**Consultation Response from KC,
Lead Local Flood Authority**

2024/90058 Penistone Road/, Rowley Lane, Fenay Bridge, Huddersfield, HD8 0JS

**Date Responded: 19th March 2024
Responding Officer: Paul Farndale
Responding Ref:**

Detail
FLOOD ROUTING PLAN

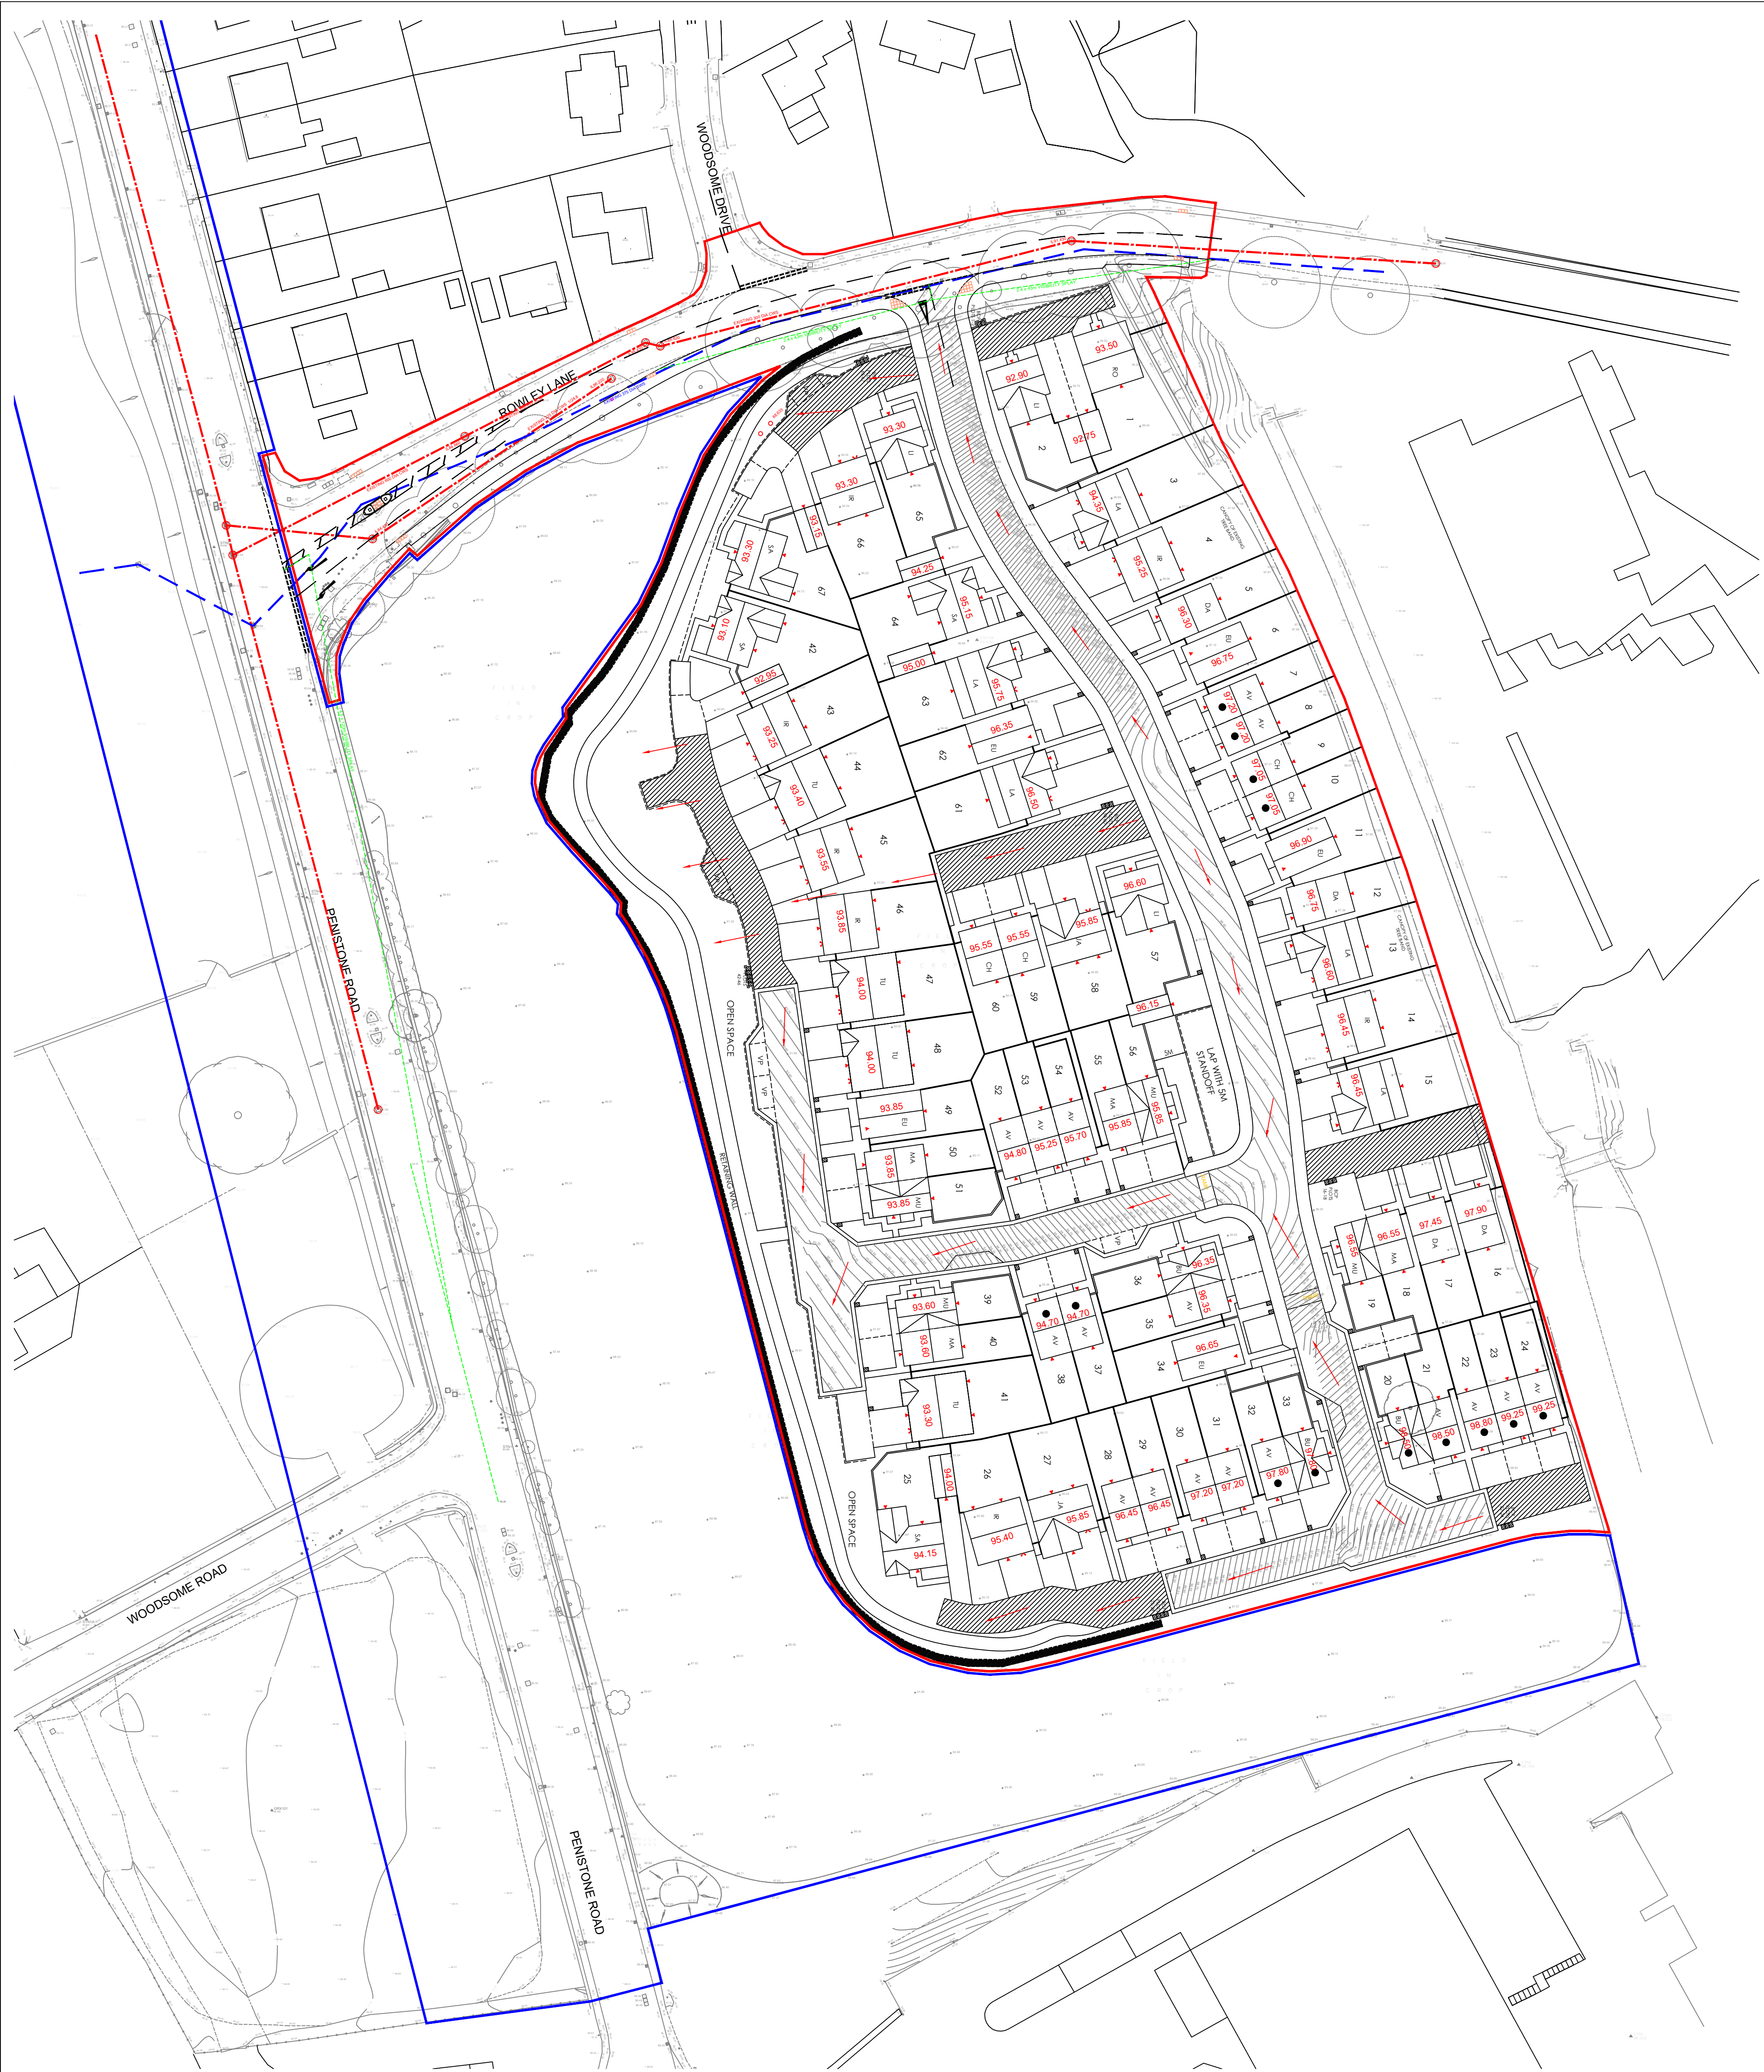
Flood routing drawings show that the proposed road network for both phases will act as a conduit for overland flow and no curtilage will be affected.

We can recommend that this condition be discharged.

Detail
ENGINEERING FEASIBILITY

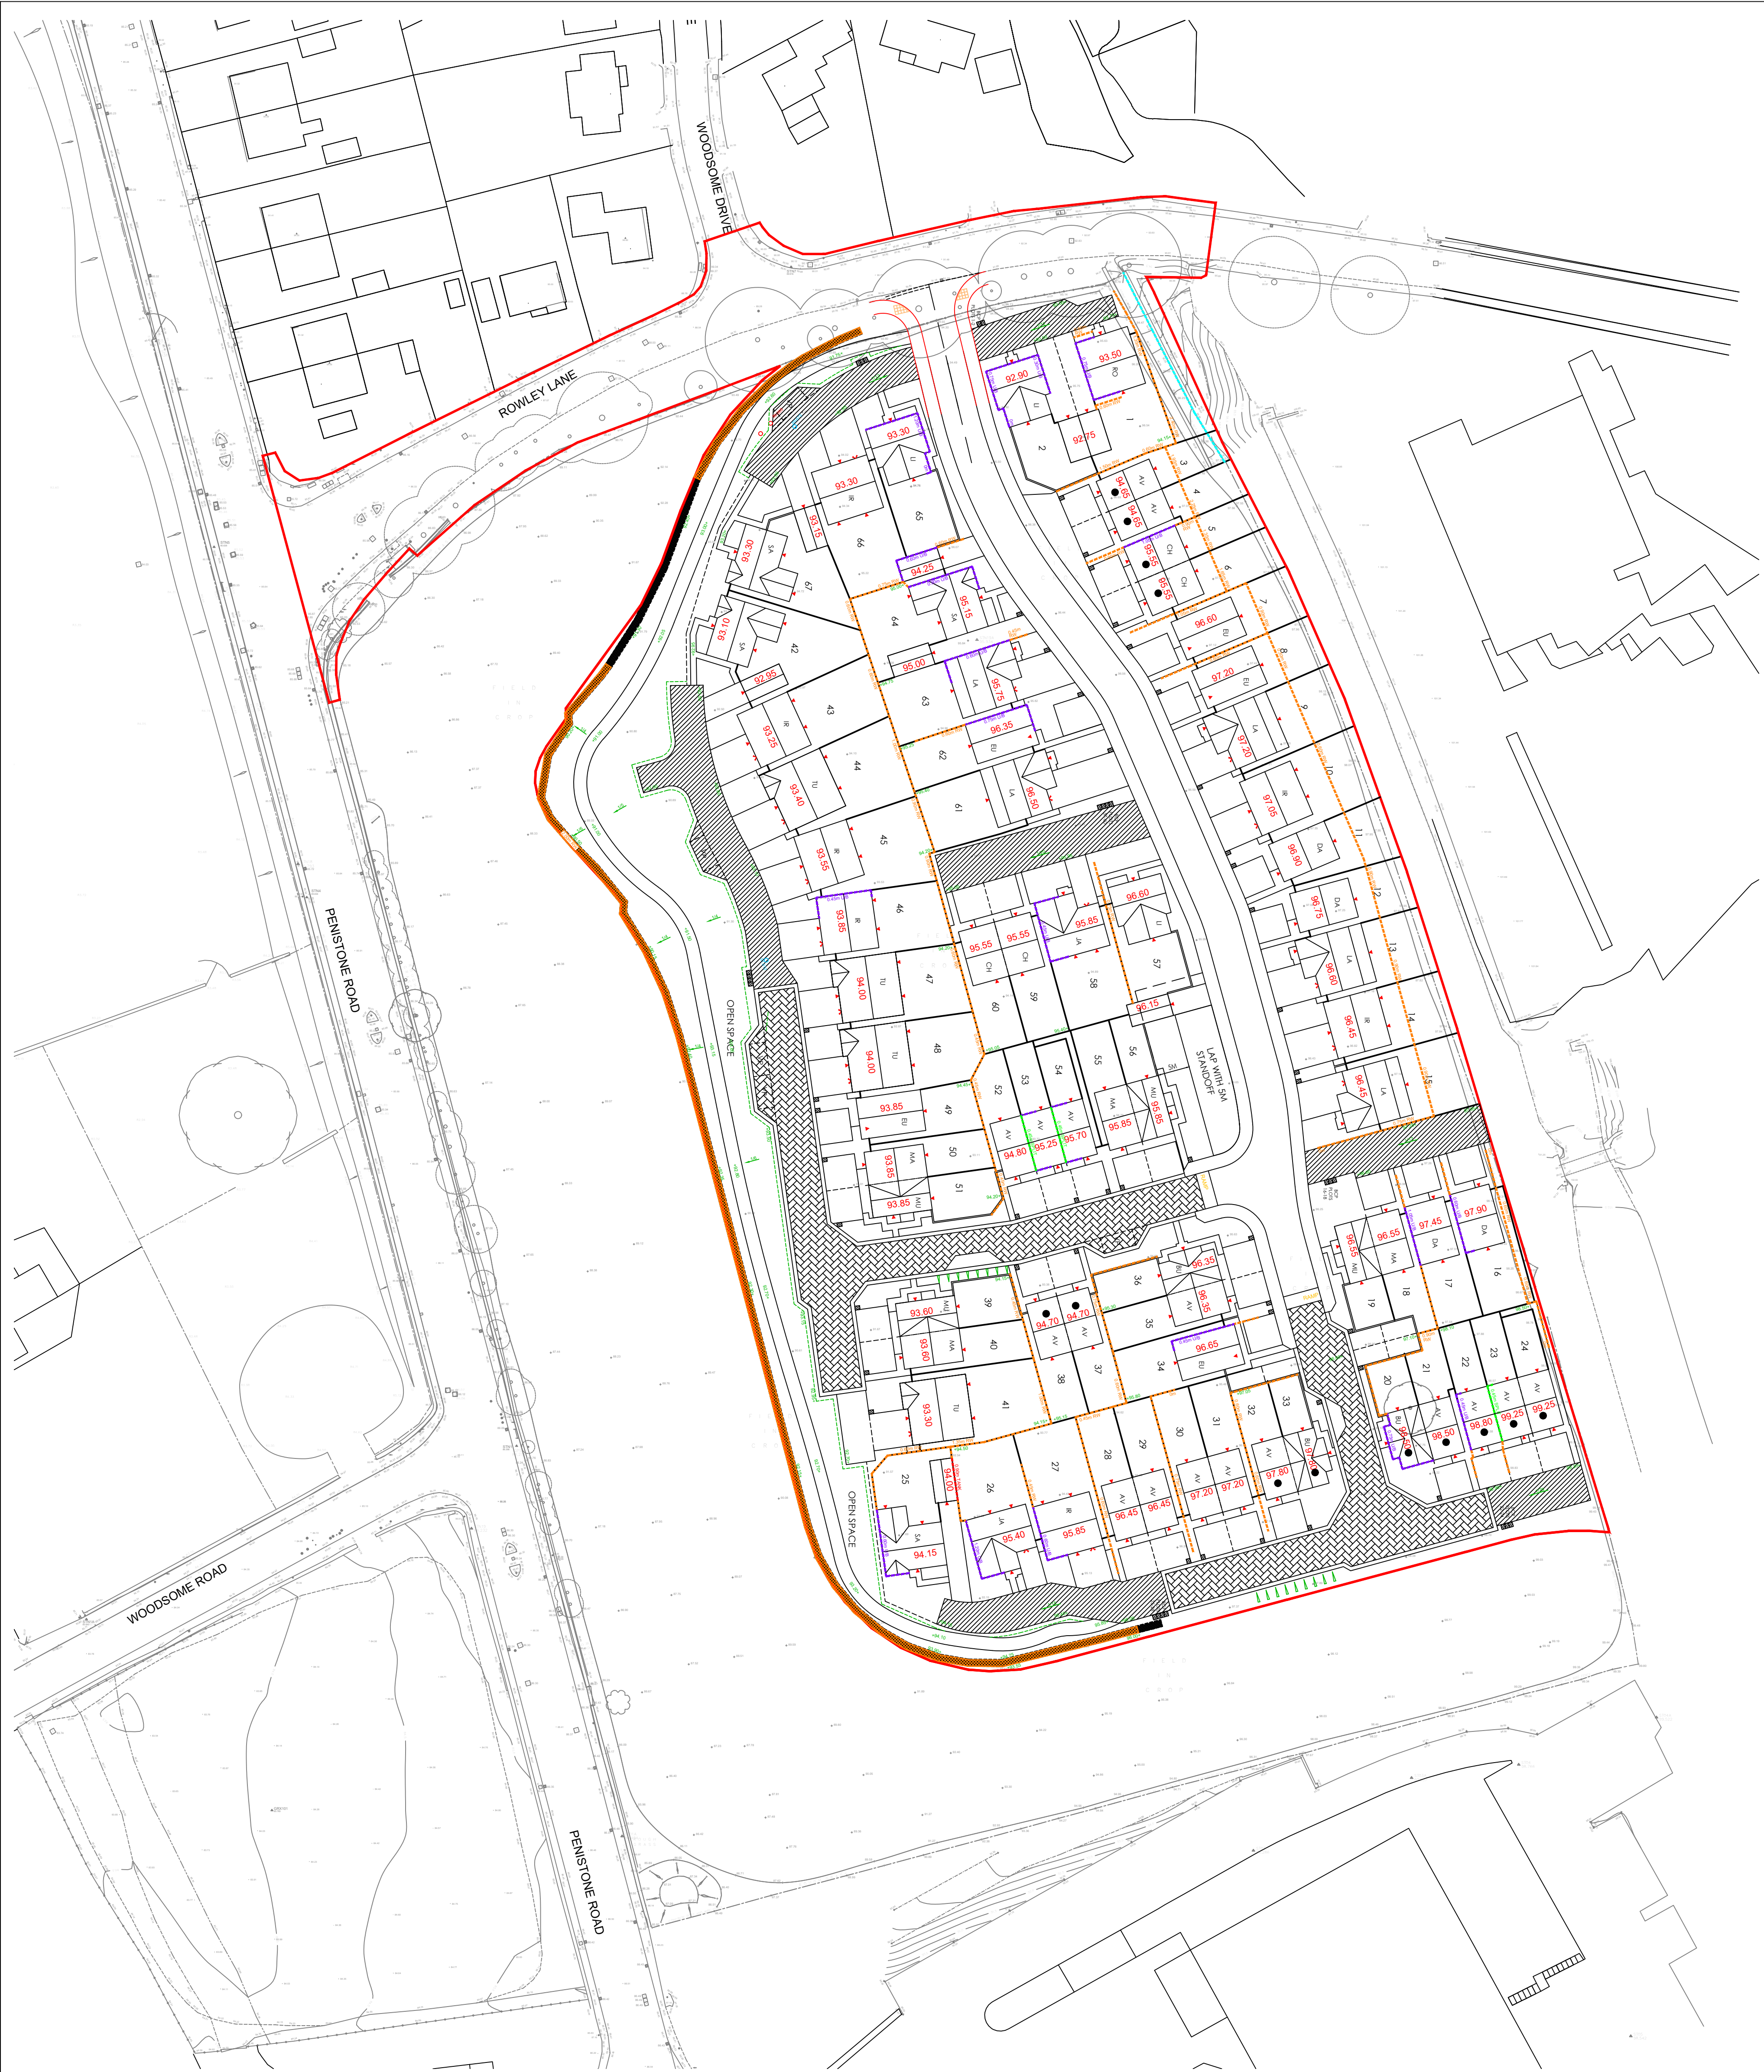
An indicative location for a tank has been shown on drawings. This differs for the larger scheme in the original plan. A demonstration on how future development can be attenuated by a gravity only system is required.

We do NOT recommend that this condition can be discharged at this point in time. Further information is required.
